Application for Listed Building Consent to install boiler in the kitchen. Install shower room adjoining the cloakroom. Close wall opening between the lounge & dining room & replace front outdoor light fitting with new - This application may affect the character and appearance of Littlehampton Sea Front Conservation Area.

41 Western Road Littlehampton

Thank you for your internet representation made on 3rd July 2019 which has been recorded as '**no objection**' with the comments as follows:

X REPRESENTS BOILER FLUE 10 CM X 80 CM

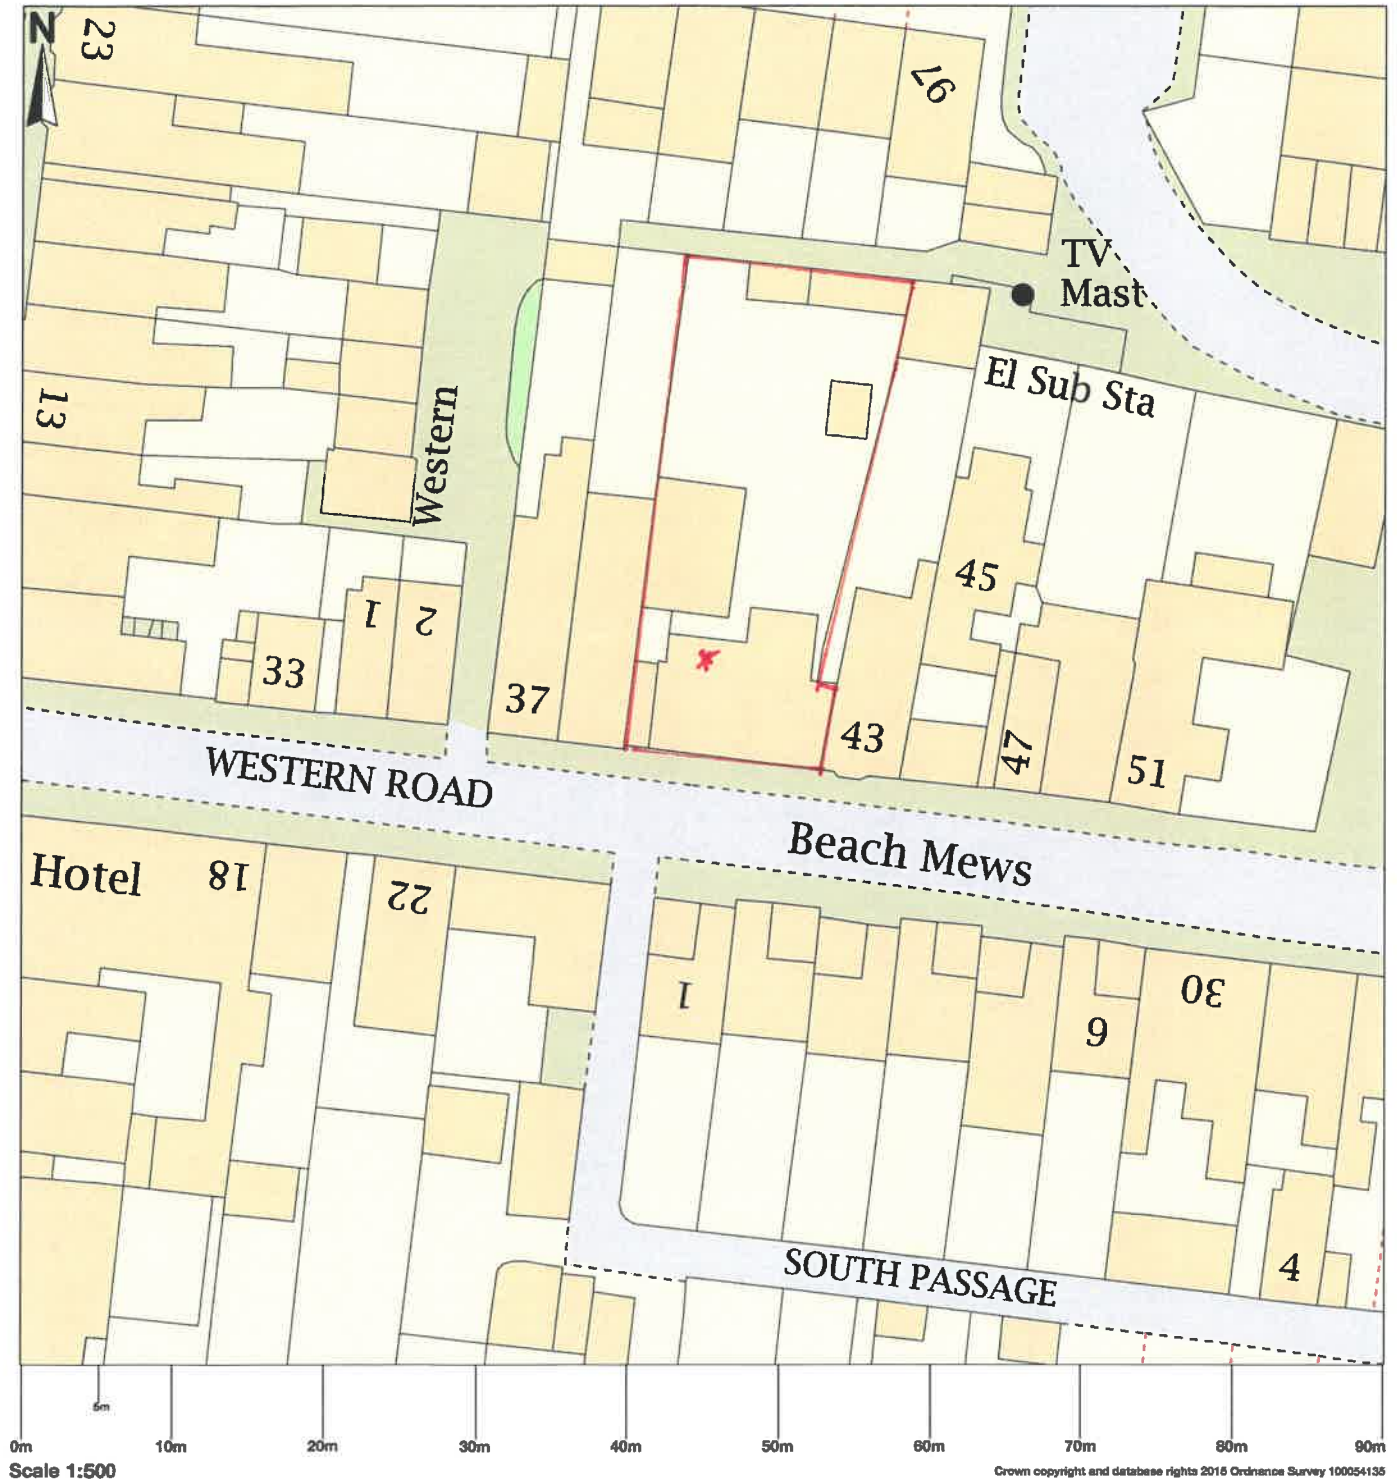
Given the location of the proposed flue there will be no adverse affect on the conservation area. However it is suggested that the flue be painted black.
